25 November 2016

RE: Notice of Exhibition – Moorebank Precinct West Stage 2 (SSD 7709)

In response to the exhibition material, Campbelltown Council makes the following comments:

CONCURRENT A-DOUBLE & B99 VEHICLE MANOEUVRE
1:250 SCALE

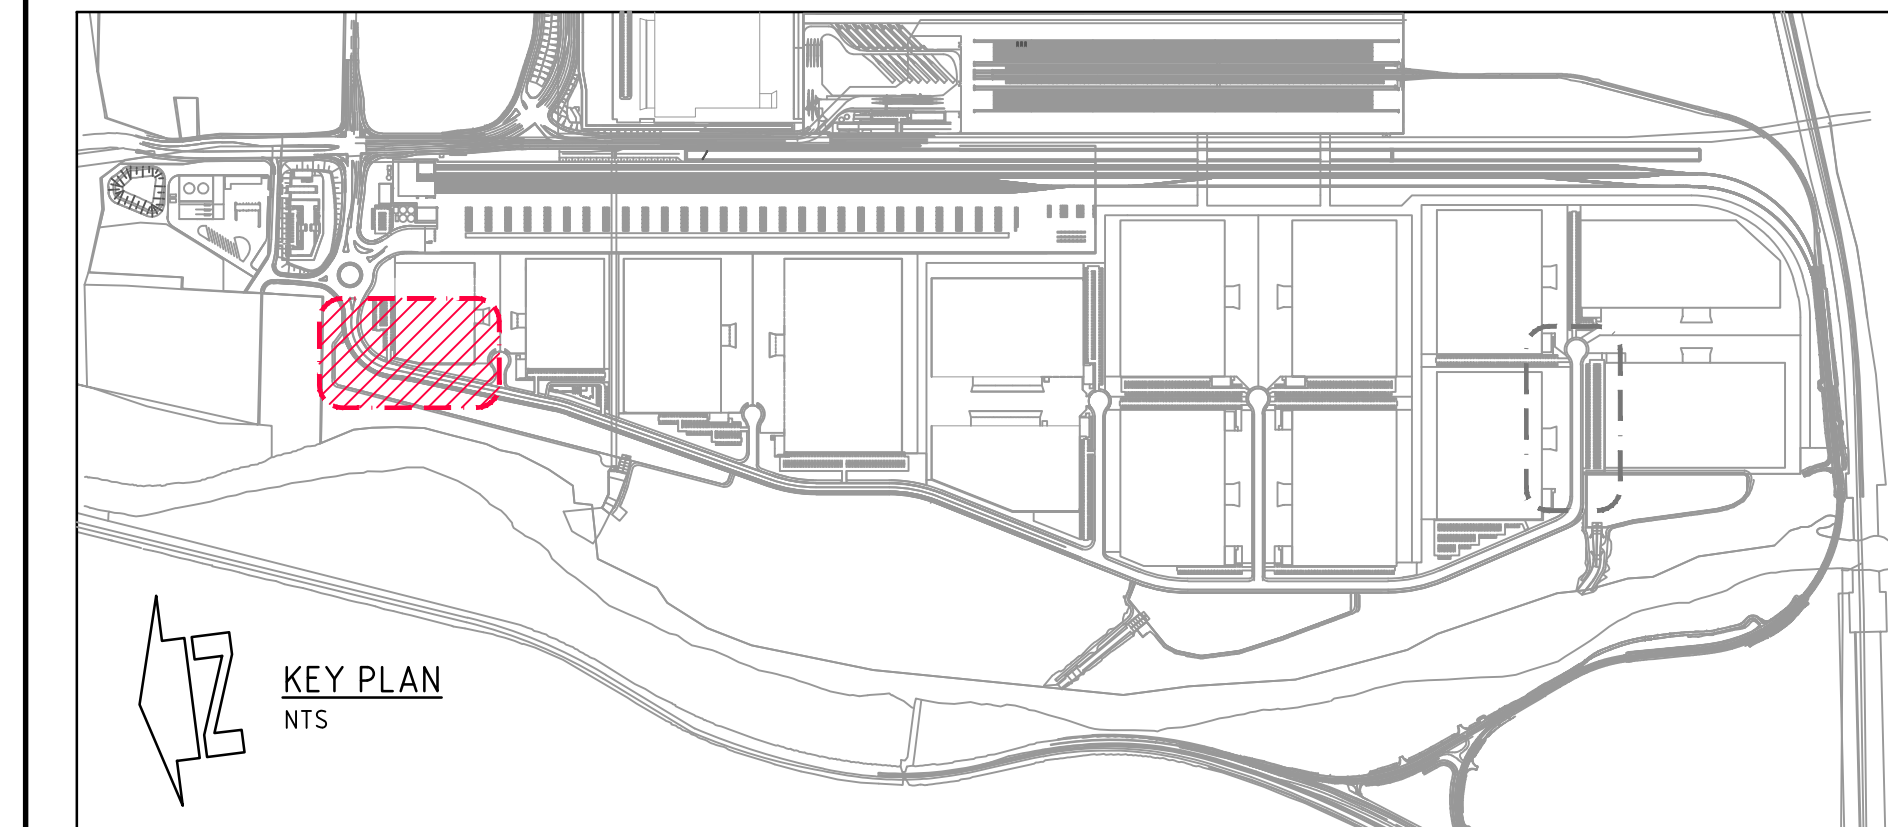
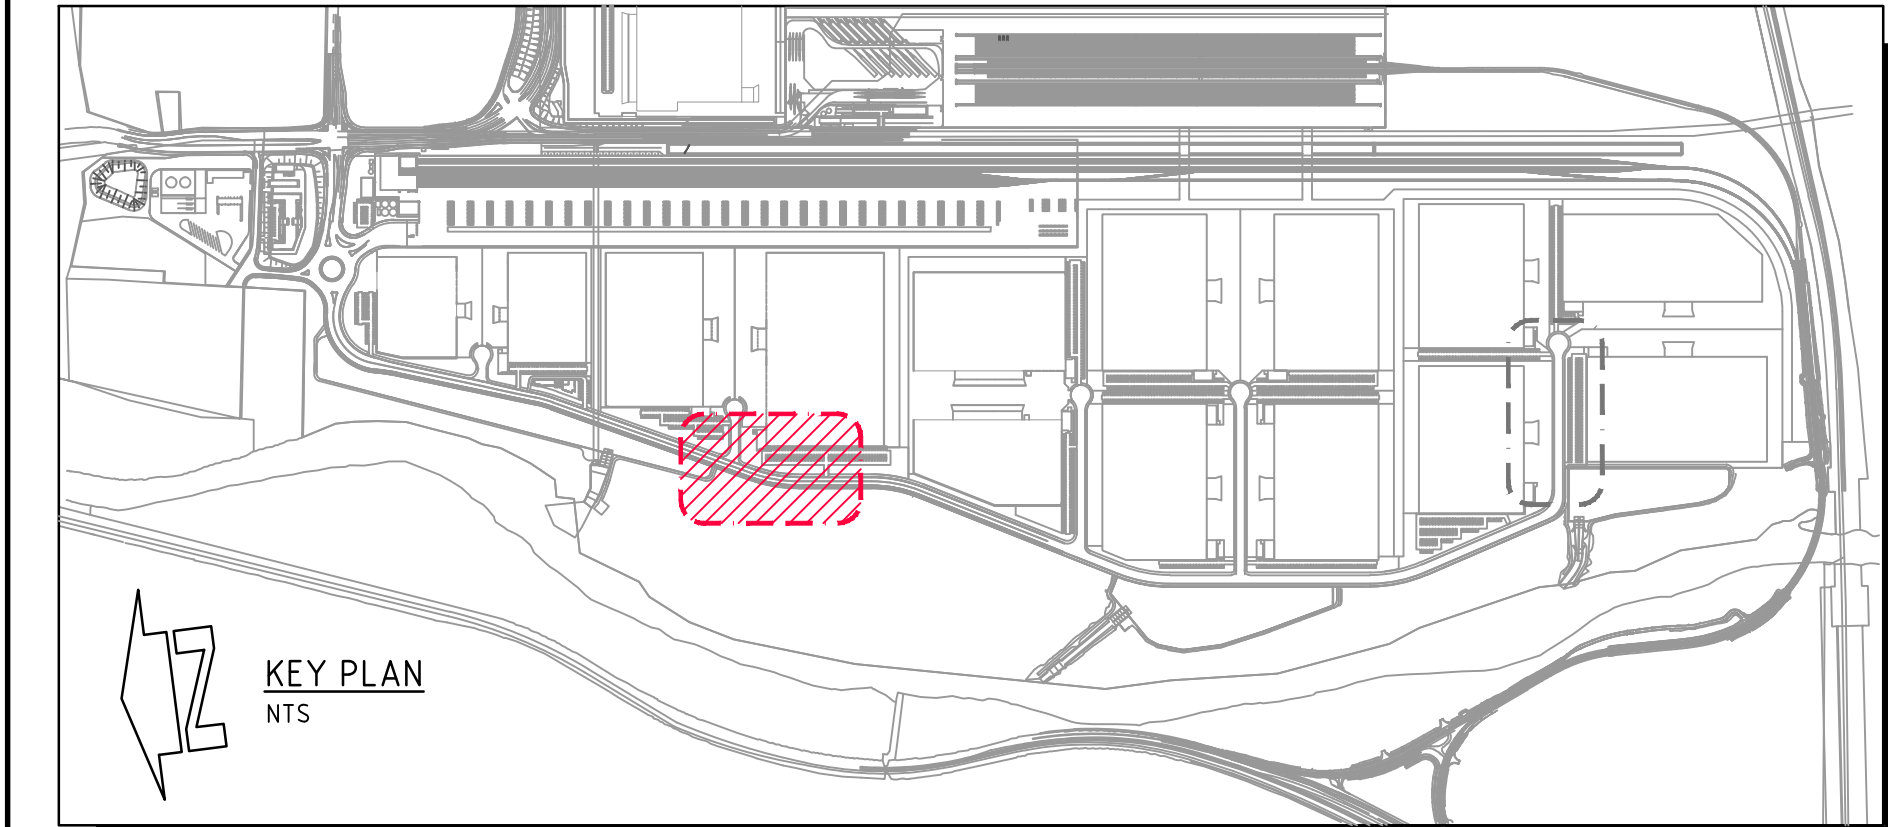
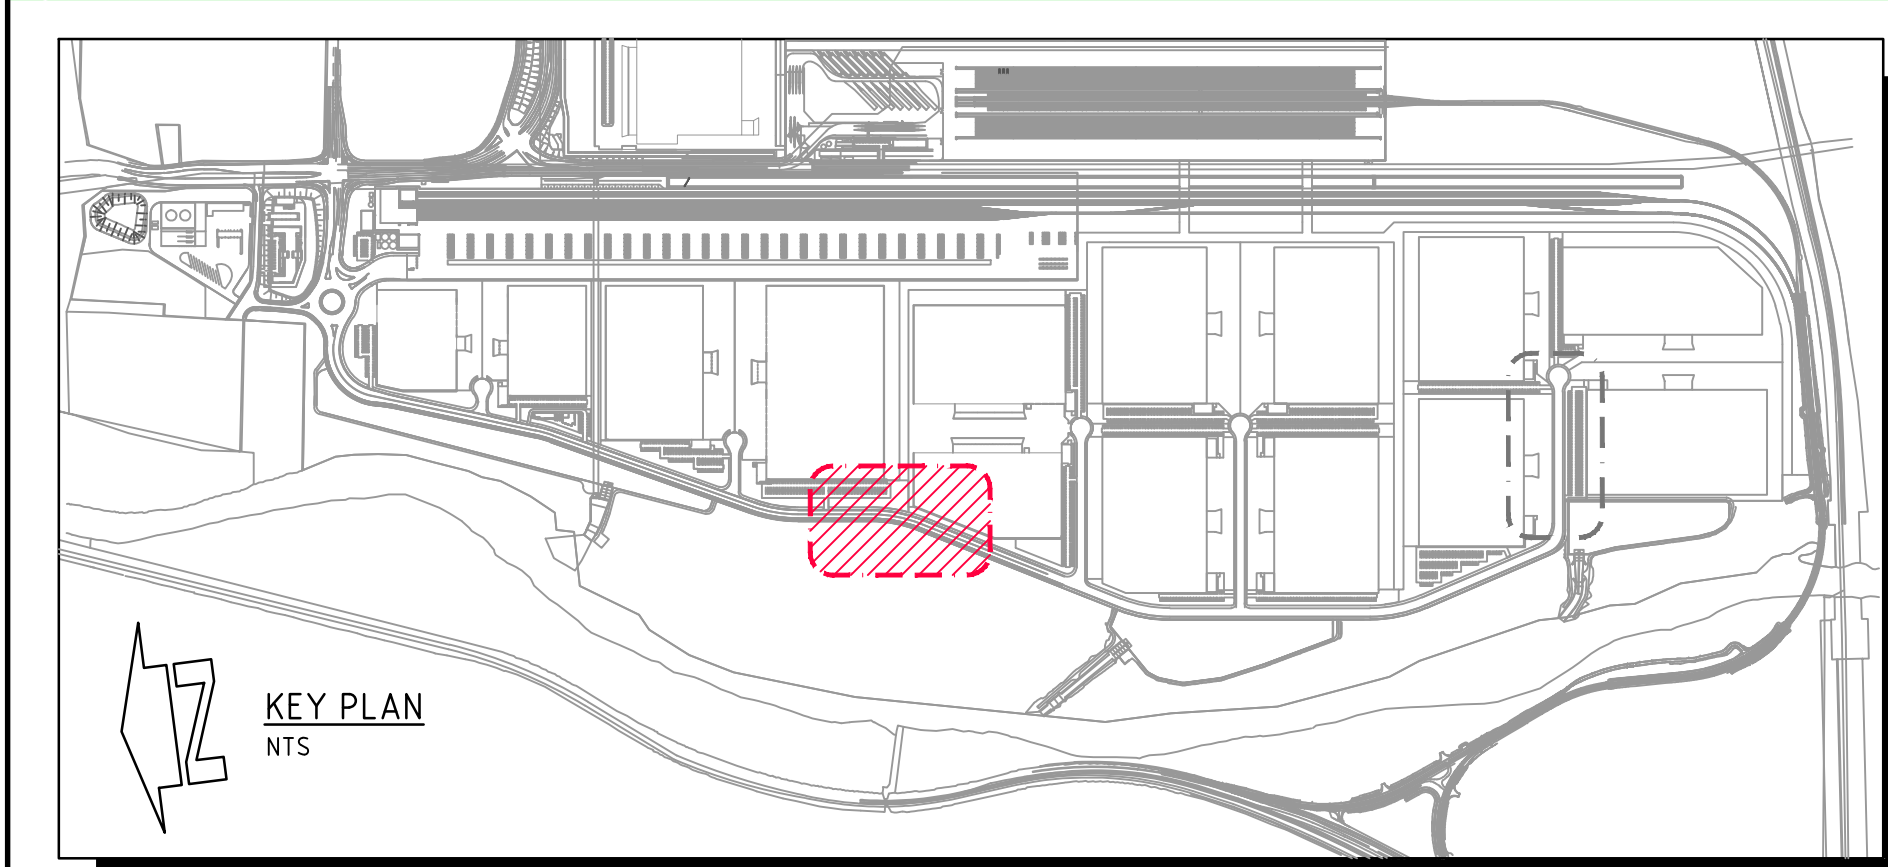
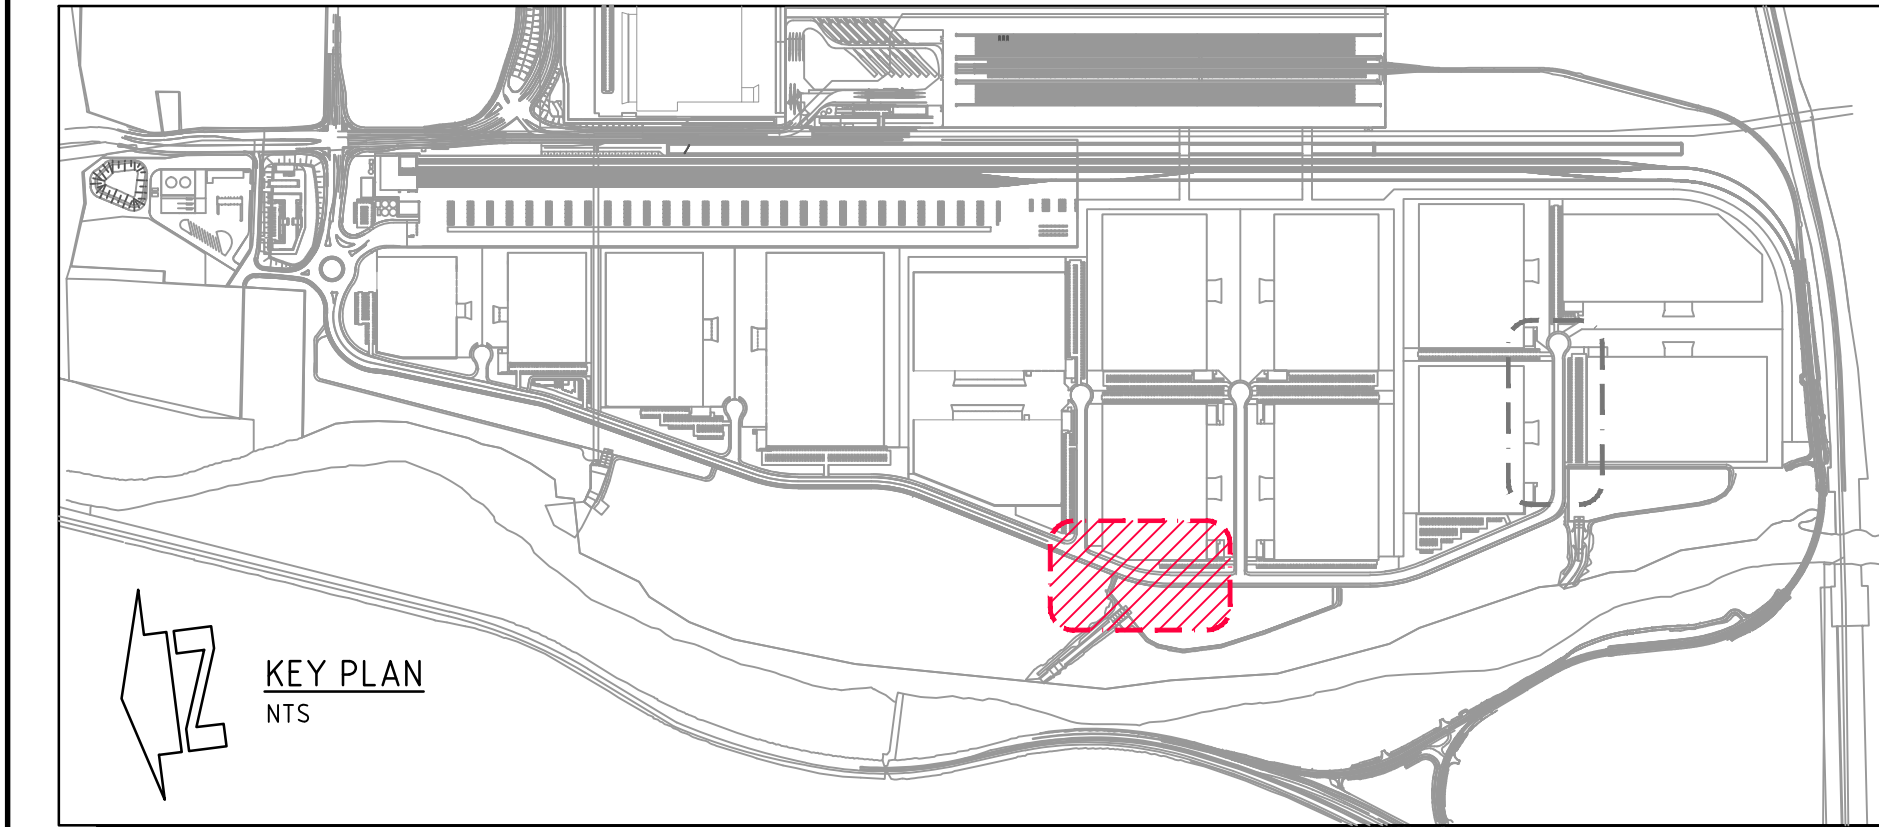
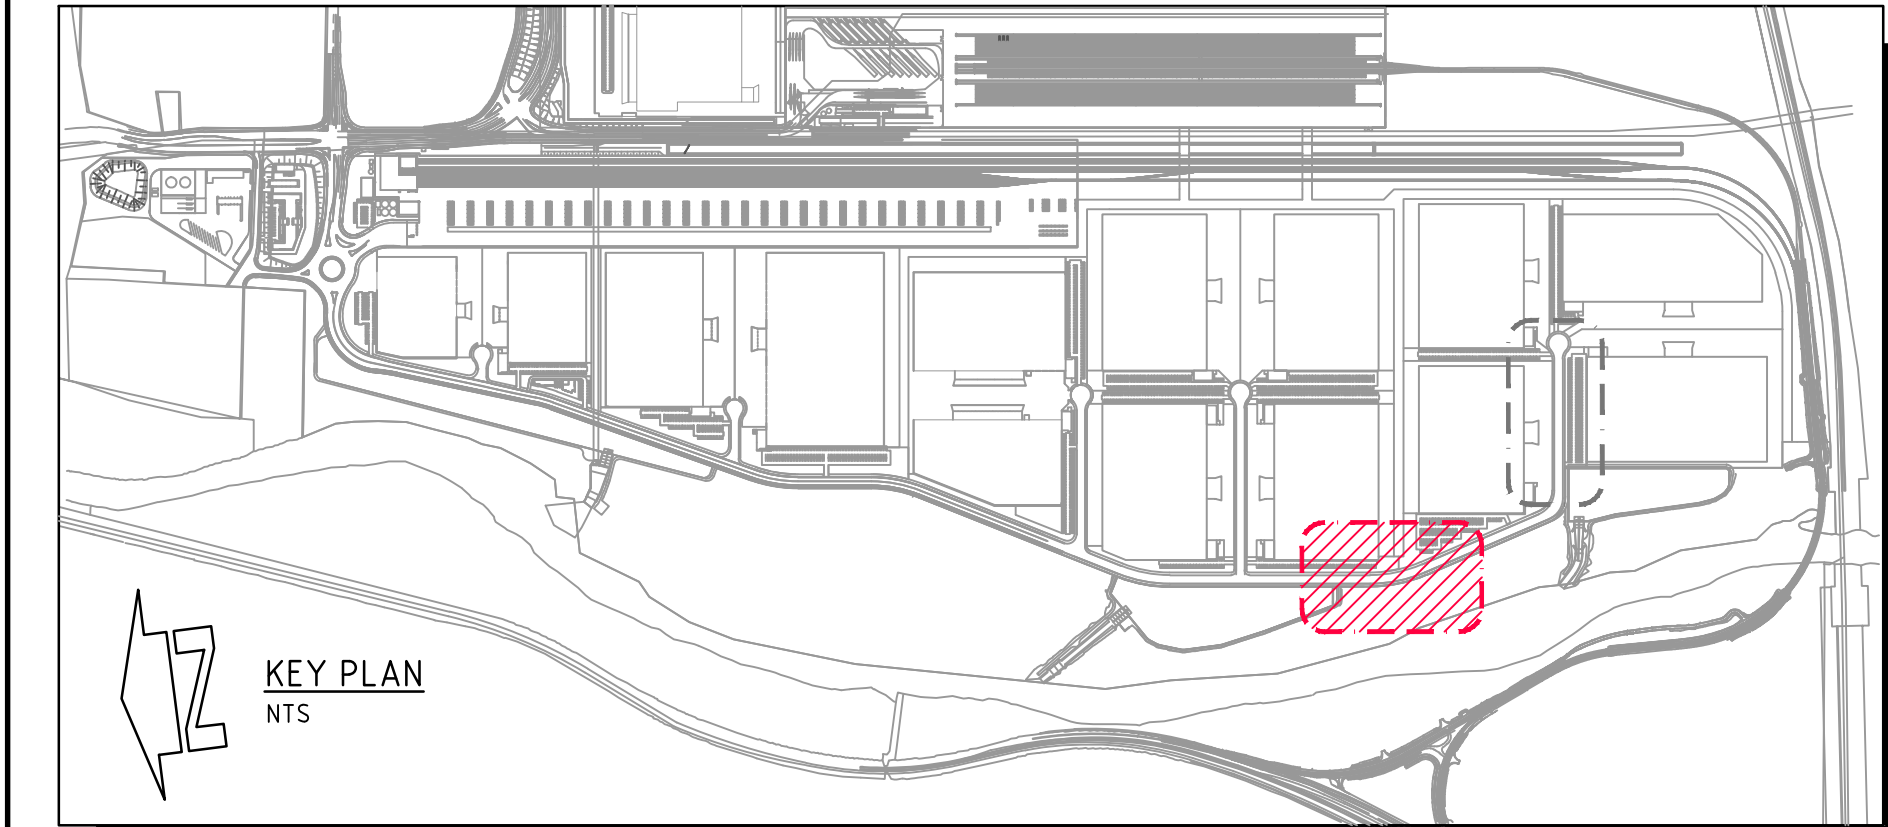
The proposed intersection design with Moorebank Avenue/Anzac Road appears to be inconsistent with the concept approval (SSD 5066) for the facility, refer to Schedule 4 – Condition E12:

All future Development Applications shall demonstrate how the main access to the site has been designed to prevent heavy vehicles associated with the facility from using Moorebank Avenue South, and should be accompanied by detailed engineering drawing(s).

Appendix 'G' to the current application clearly demonstrates that the intersection has been made viable for trucks (a-doubles maximum) to turn right onto Moorebank Avenue and head south, which is not considered to be compatible with the concept approval.

Even if the proponent suggests that the trucks would be heading in that direction to access Precinct East only and not continuing on to utilise the Cambridge Avenue Georges River crossing, the fact remains that the proposal is not consistent with the condition and there are no safe-guards proposed, aside from 'education of drivers' accessing the terminal. It could be argued that if the PAC considered driver education to be sufficient, that the wording of Condition E12 would have been different.

- 3.7 The proposal has assessed the intersections along Cambridge Avenue to determine impacts of the development. As with the Glenfield Waste proposal, the issue is not the intersections, but the number of heavy vehicles trying to pass on the causeway itself. Any increase could have a negative impact on safety. This has not been addressed by the current application and is of particular importance to Council, noting the intersection design in Appendix 'G'.
